Project Name: SEVEN BAR RANCH

**CITY OF ALBUQUERQUE  
PLANNING DEPARTMENT  
April 19, 2006  
DRB Comments**

**RE: Tract B-9J-1A, Seven Bar Ranch/minor plat**

**DEVELOPMENT REVIEW BOARD**  
**TRANSPORTATION DEVELOPMENT**  
**Standard Comment Sheet**

EASEMENT DETAIL SHEET

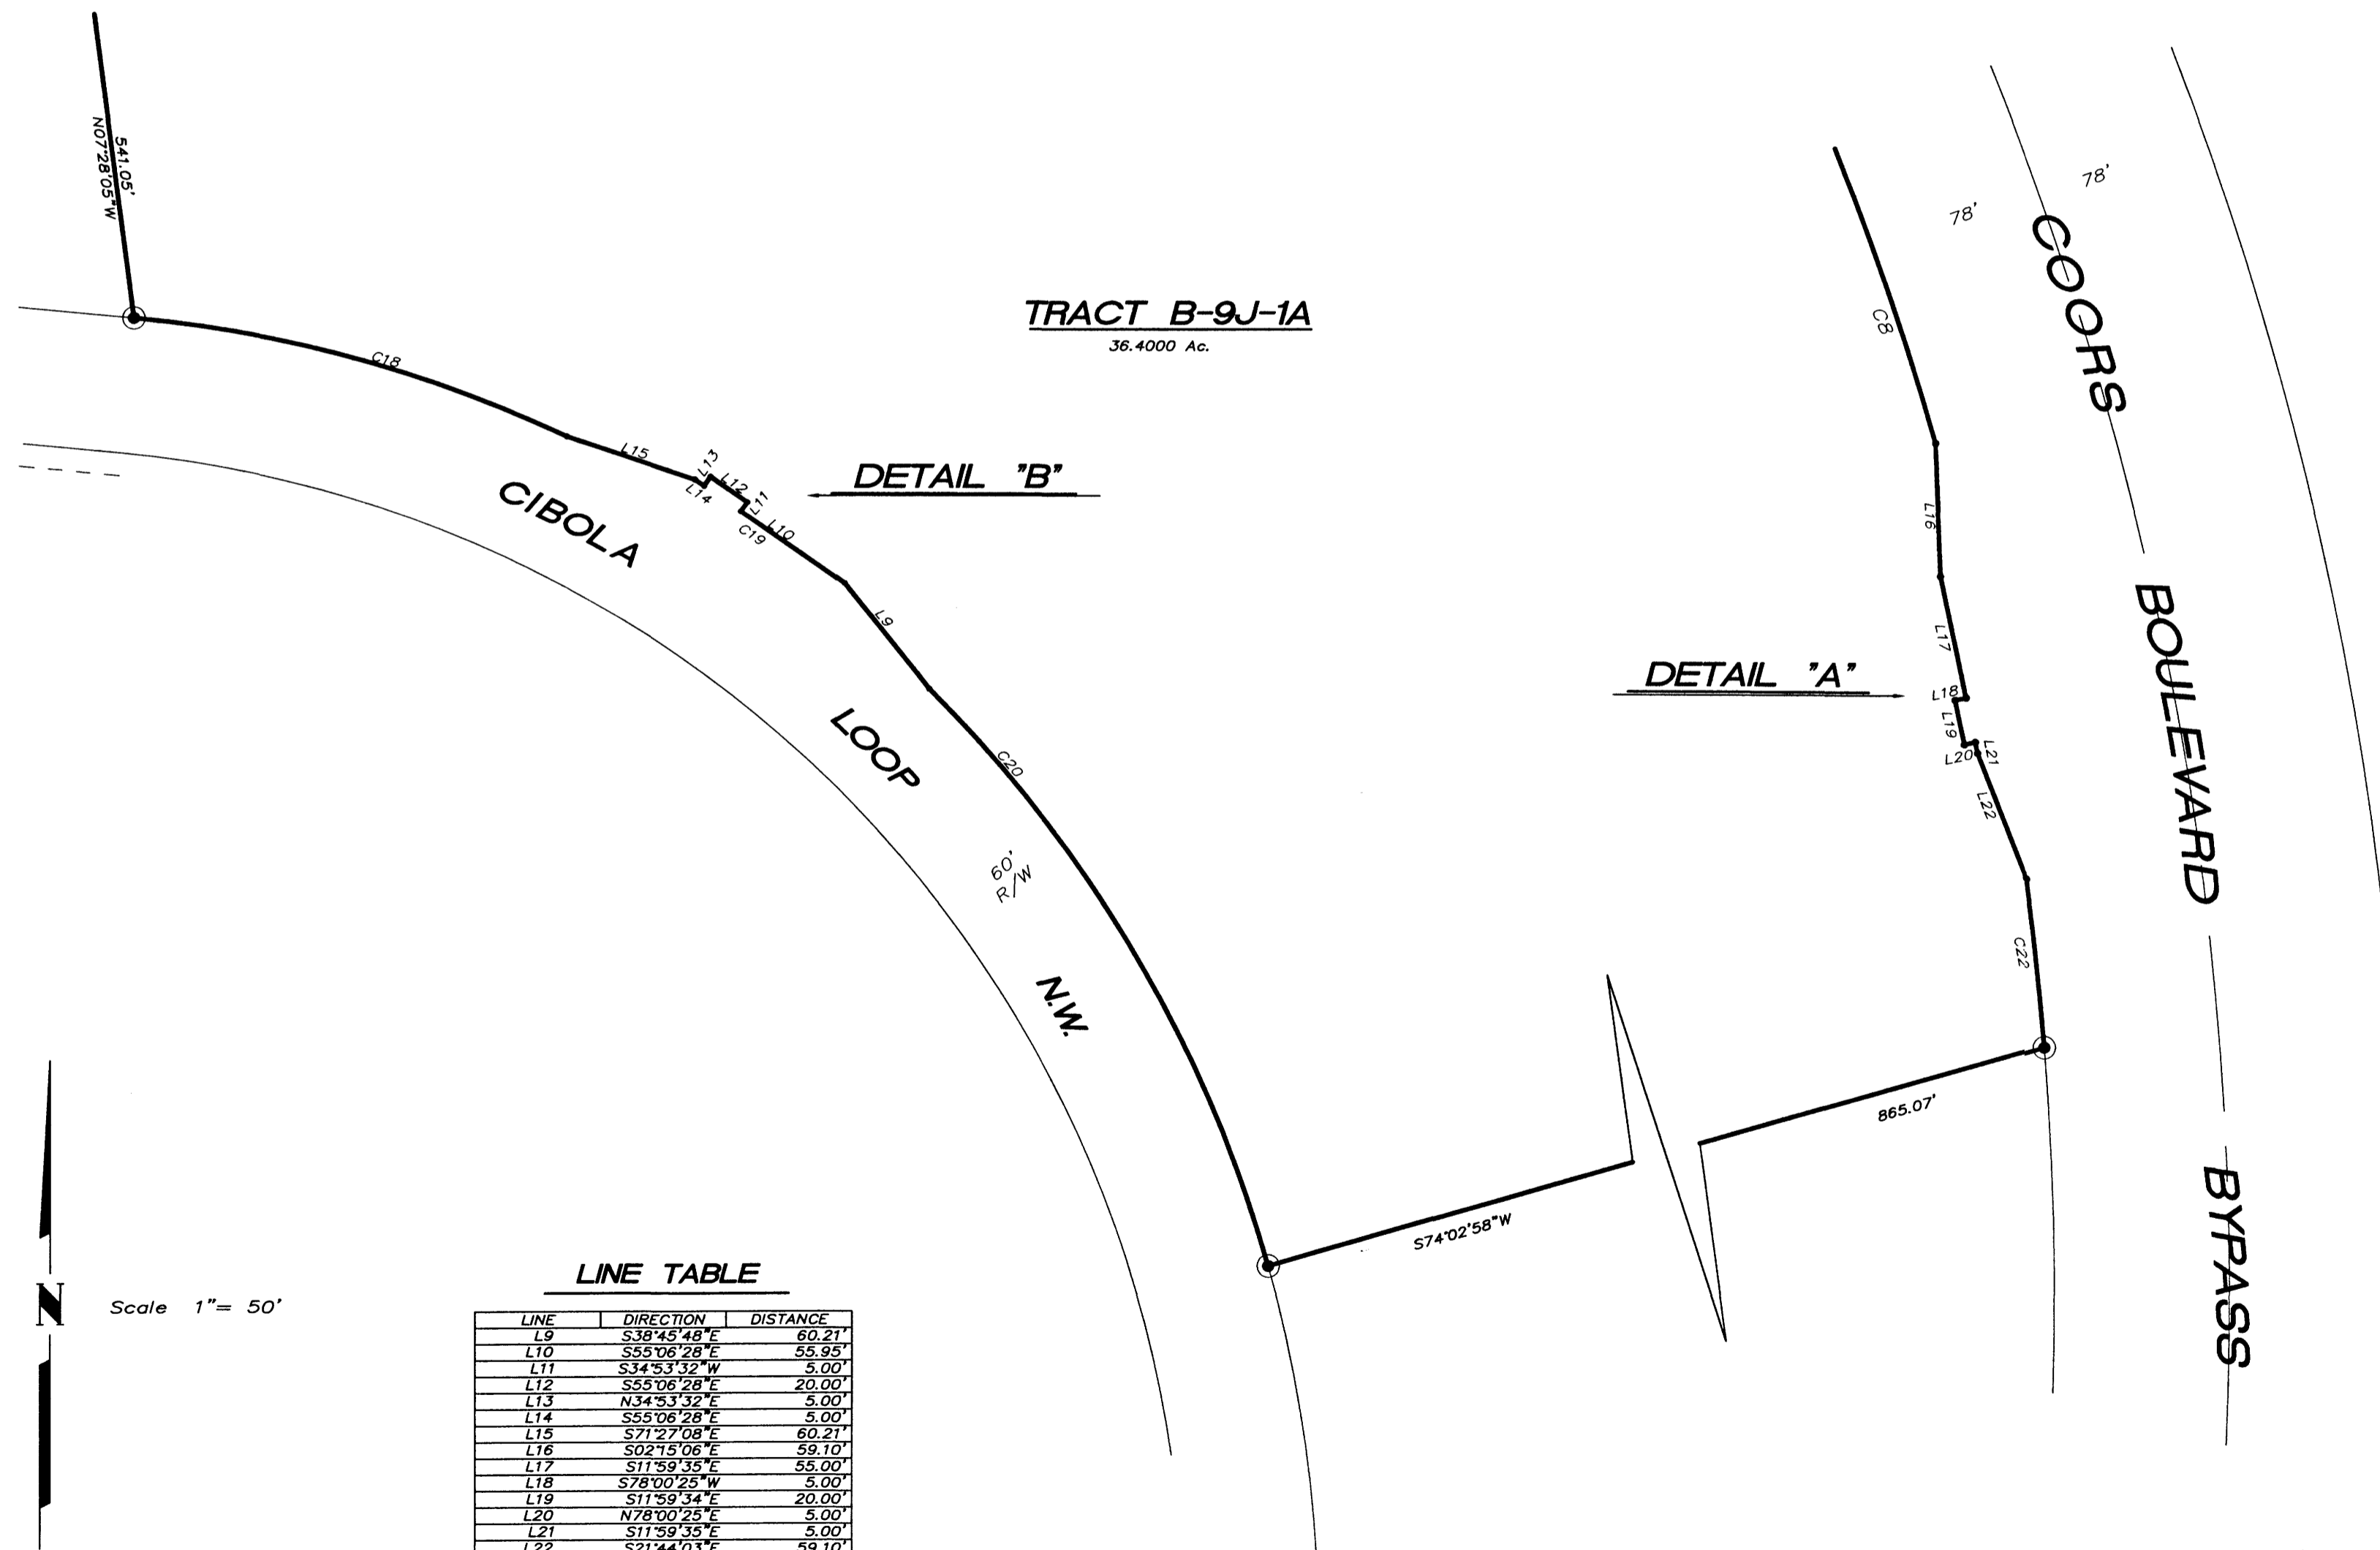
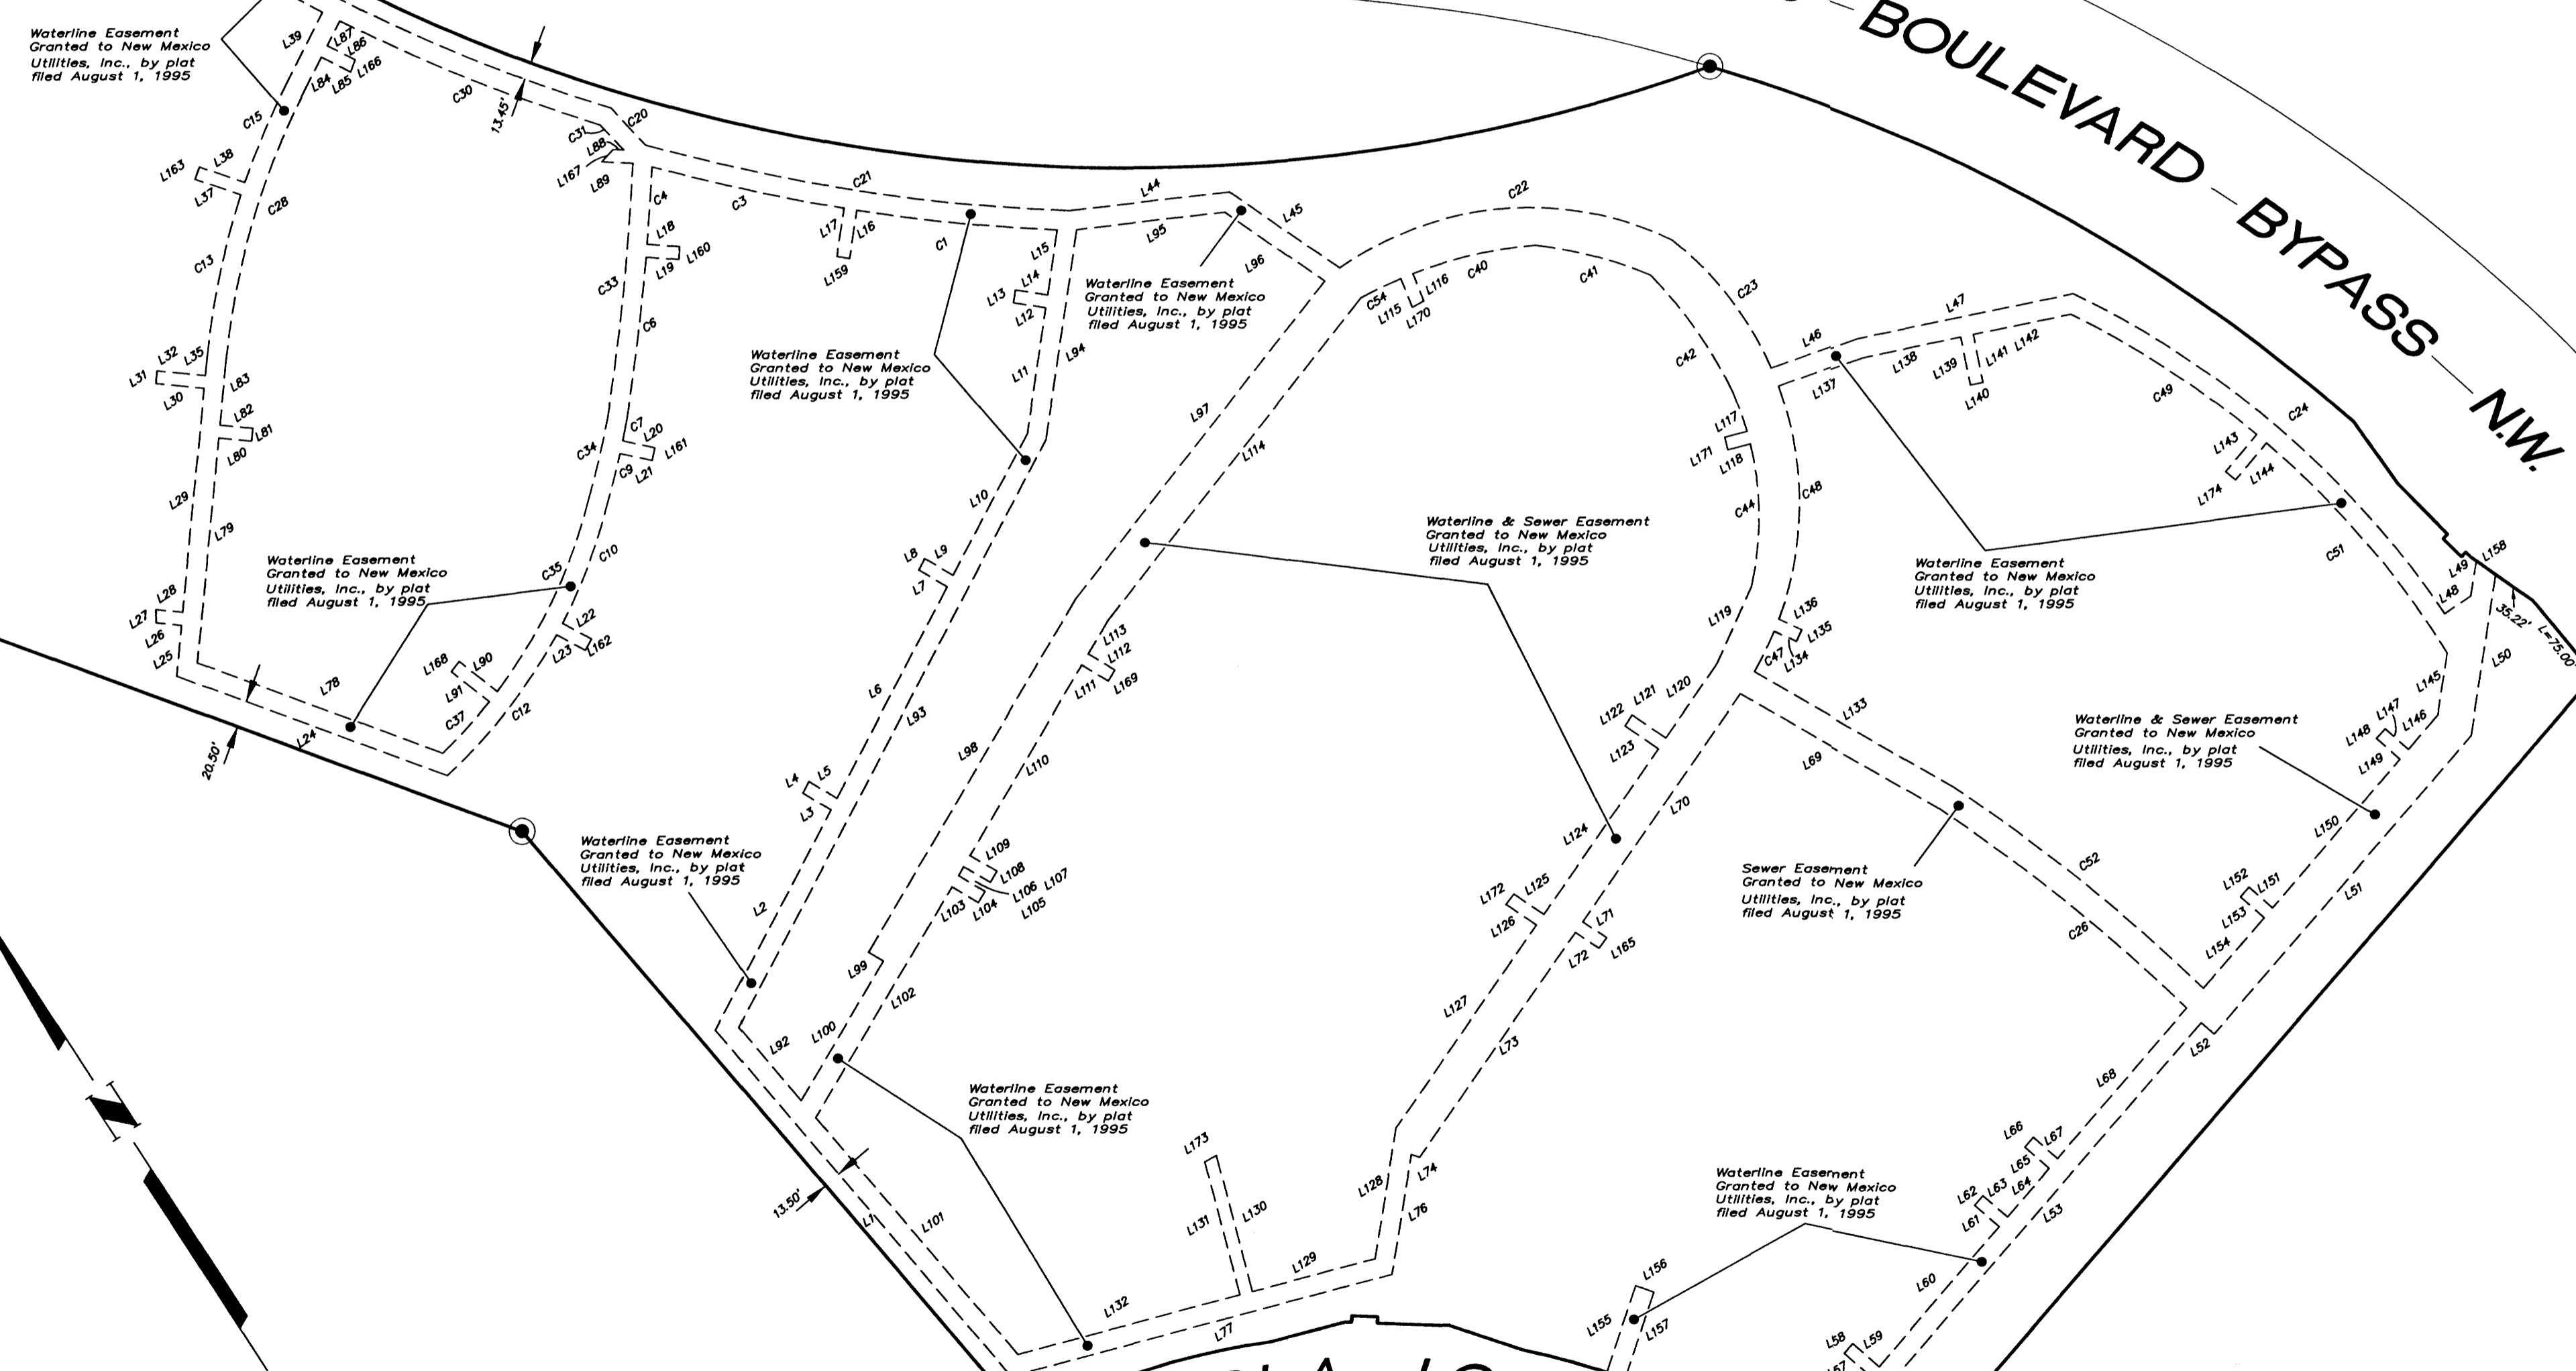
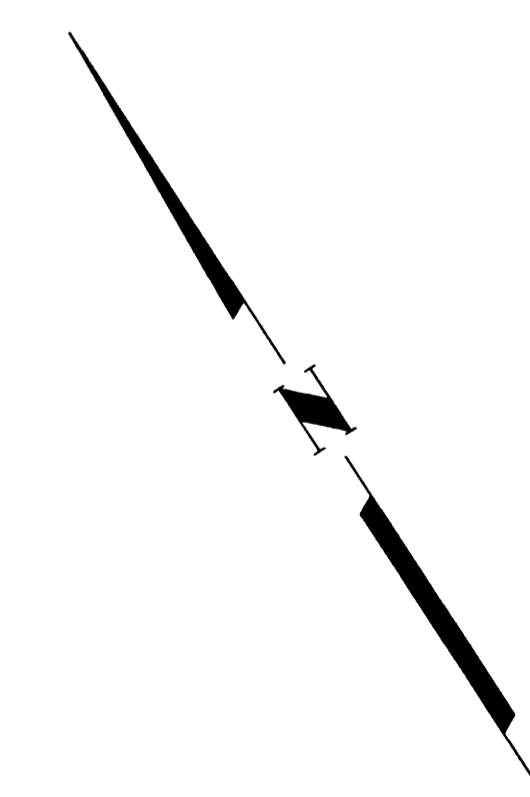
<u>No.</u>	<u>Comment</u>
1)	Where is the 2 <sup>nd</sup> access easement?
2)	What is the paved width of Cibola Loop? Are the sidewalks in place?
3)	On sheet 4, where is tract B-9H-1B?
4)	The general x-access needs to be filed.
